Re: The Old Dairy, Rear of 3 & 5 Church Street, Littlehampton.

Thank you for your contact of 25th October 2013, advising me of an application for a proposed development of 8 dwellings at the above location, for which you seek advice from a crime prevention viewpoint.

Phill Edwards
Crime Prevention Design Adviser
Sussex Police Headquarters

SITE PLAN WITH DRAFT LEVELS
 PROPOSED RESIDENTIAL DEVELOPMENT
 THE OLD DAIRY, CHURCH STREET, LITTLEHAMPTON, SUSSEX.
 GRAHAM NICOLLS LIMITED, DESIGN + TECHNOLOGY, TEL/07990 522709

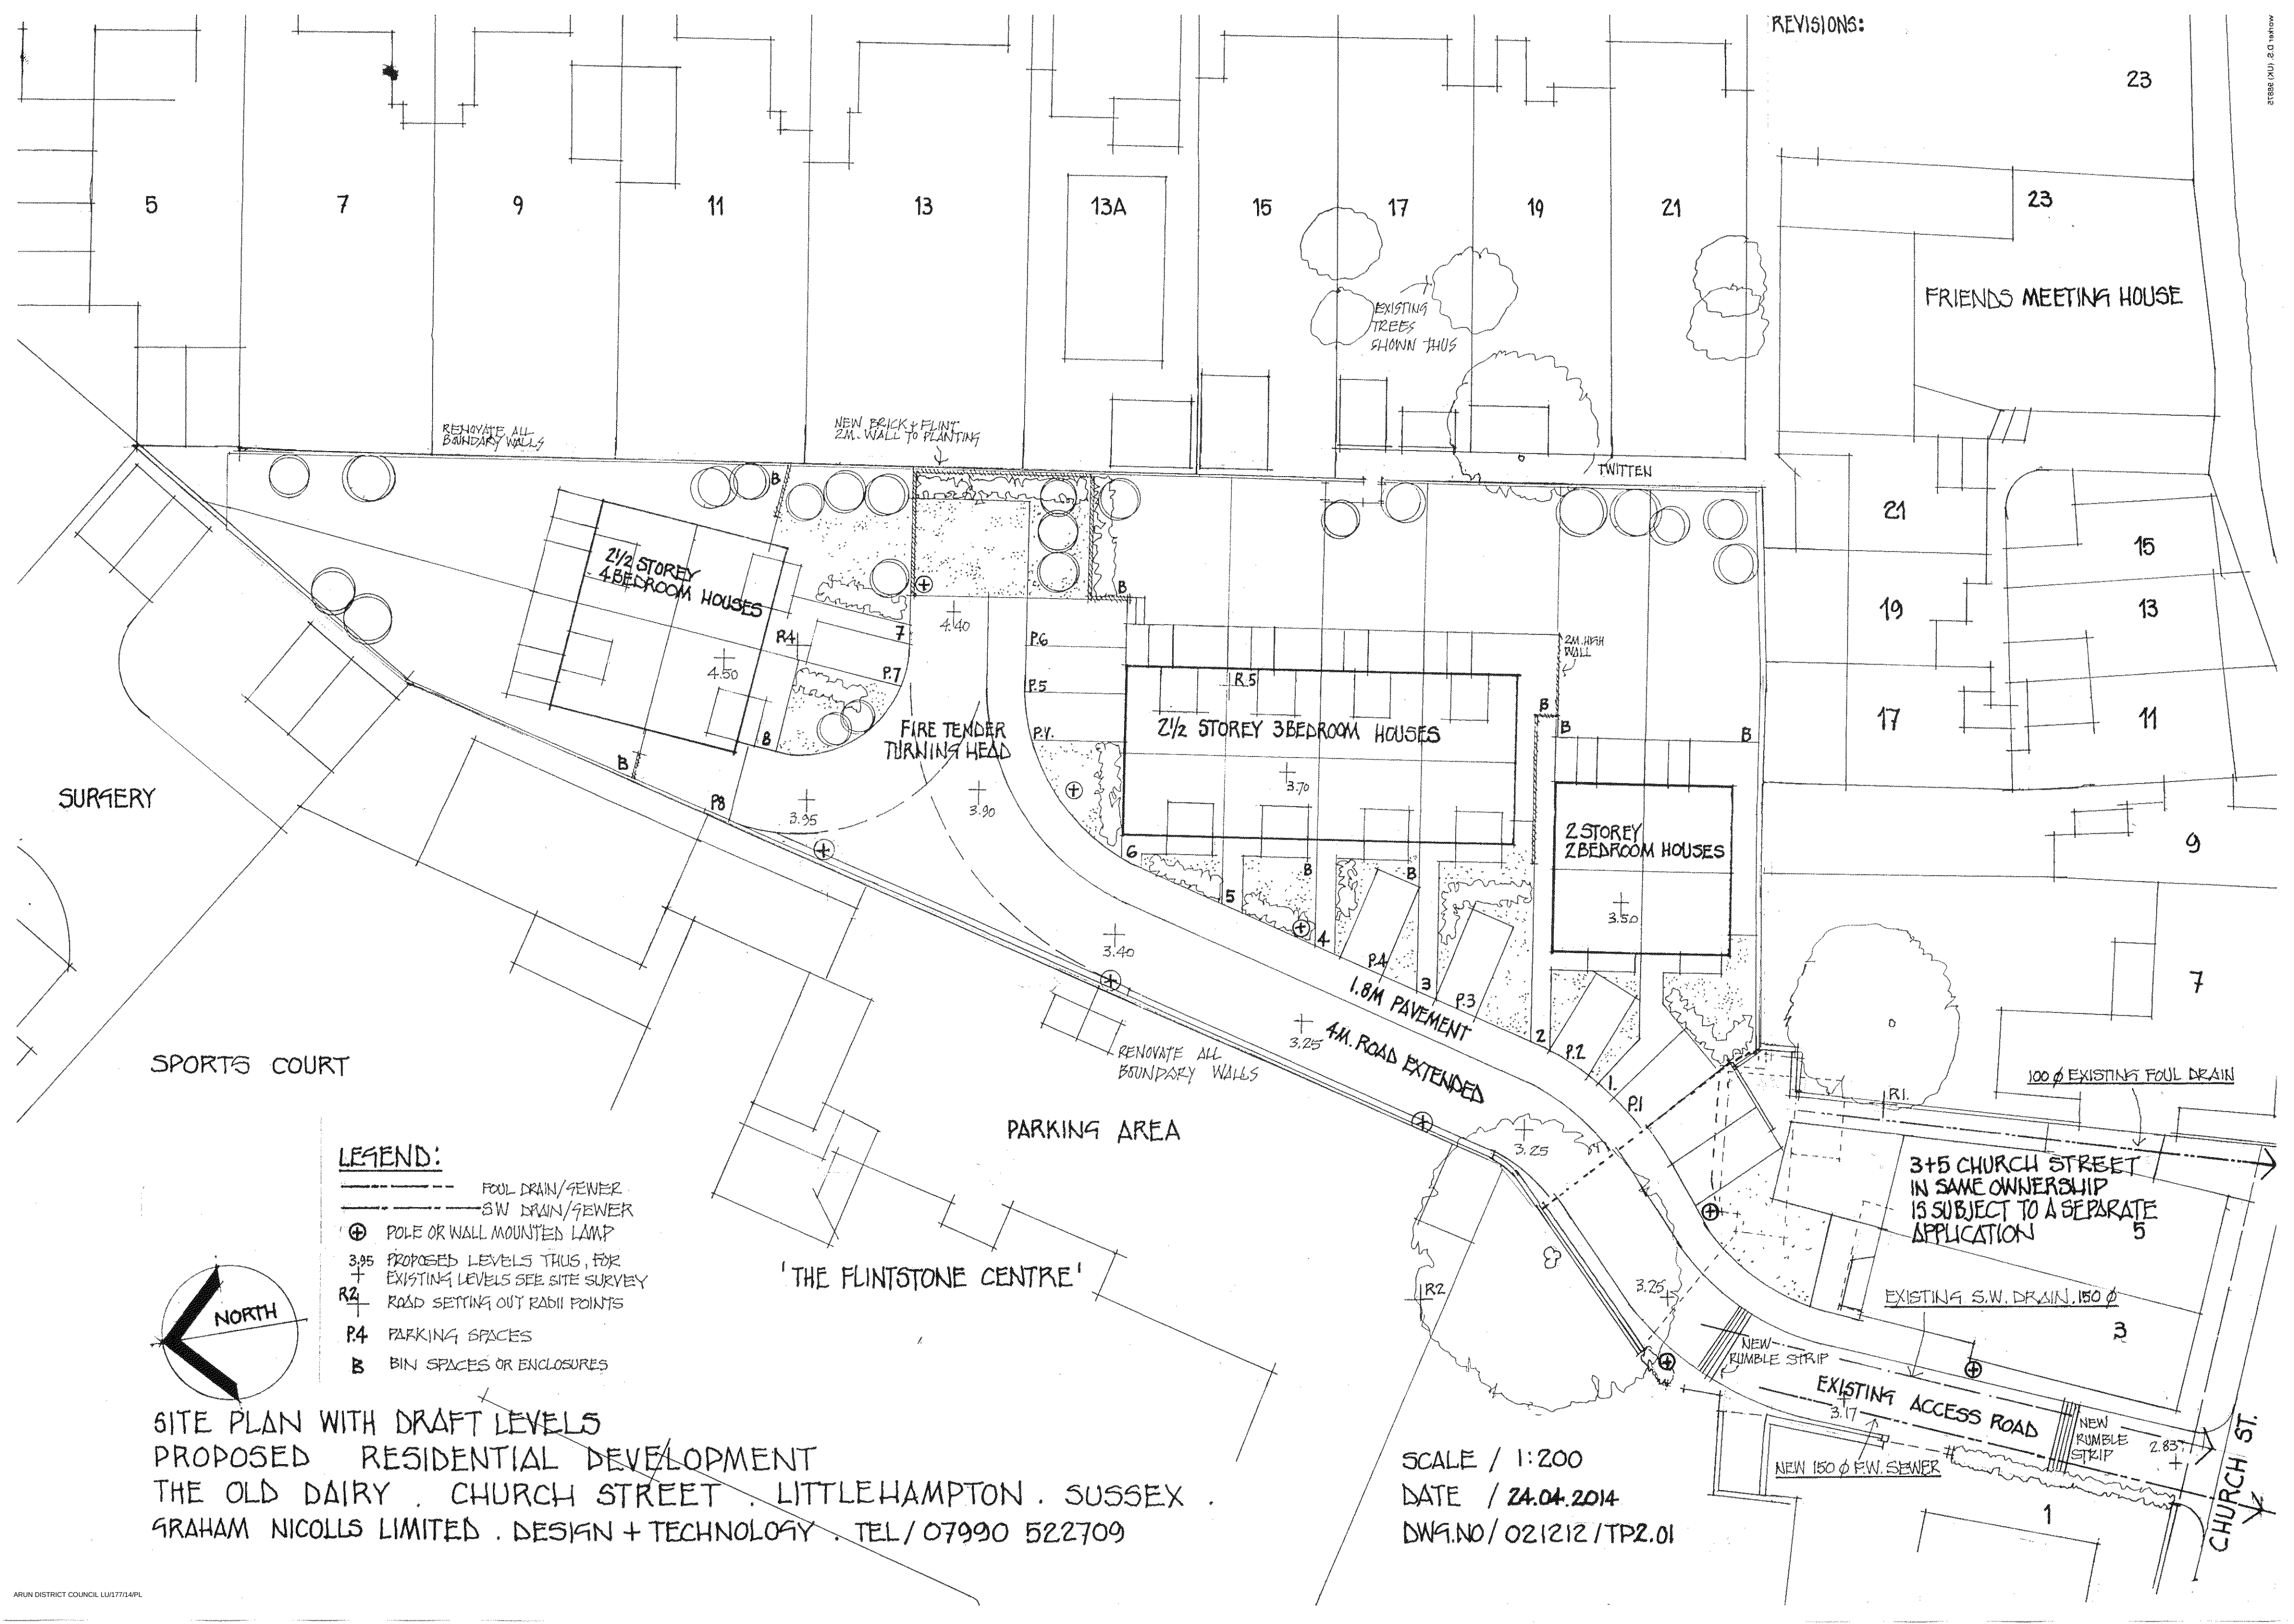
I note that there is rear access to all the properties and that the development shows outward facing dwellings which have created good active frontage with the street and the public areas being overlooked. Parking has been provided for with in-curtilage parking bays or opposite overlooked dwellings which will leave the street layout free and unobstructed.

As the first line of defence, I was pleased to note there is a 2 metre high brick and flint wall proposed. Garden perimeter fencing must be adequate and I would recommend 1.8 metre high close board fencing for the rear and side gardens where appropriate.

Gates to the rear gardens should be of the same height and construction as the adjoining fence and brought forward to the front of the building line as is possible.
